Date: 13 December 2018

Your ref: AL/118/18/OUT

Representations in relation to application for outline planning permission for up to 10 dwellings at Ryefields Farmhouse Oak Tree Lane, Woodgate, PO20 3GU (ref. AL/118/18/OUT)

Indicative site plan

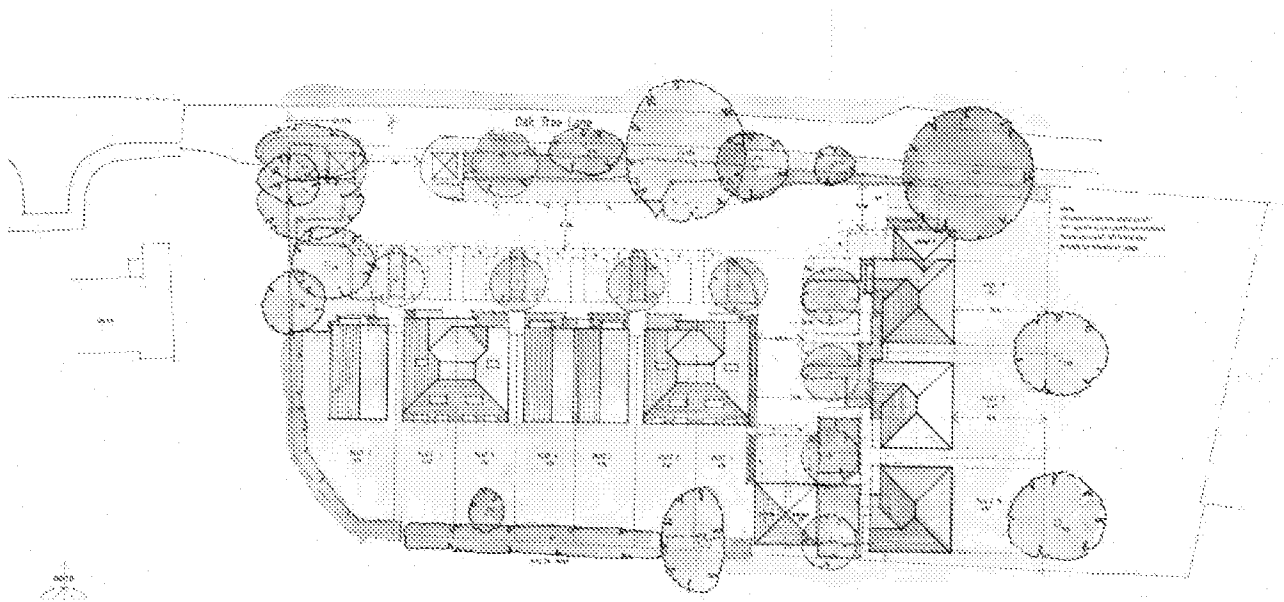
- 1 It is important that every opportunity is taken to ensure that the proposed development successfully integrates with the wider BEW site as required by Policy H SP2c SD5. Although only shown indicatively, the proposed internal road layout is not suitable for connection to the wider BEW site and appears to create a cul-de-sac arrangement. Furthermore, by coming forward in isolation of the wider BEW site it is divorced from local services and public transport connections.
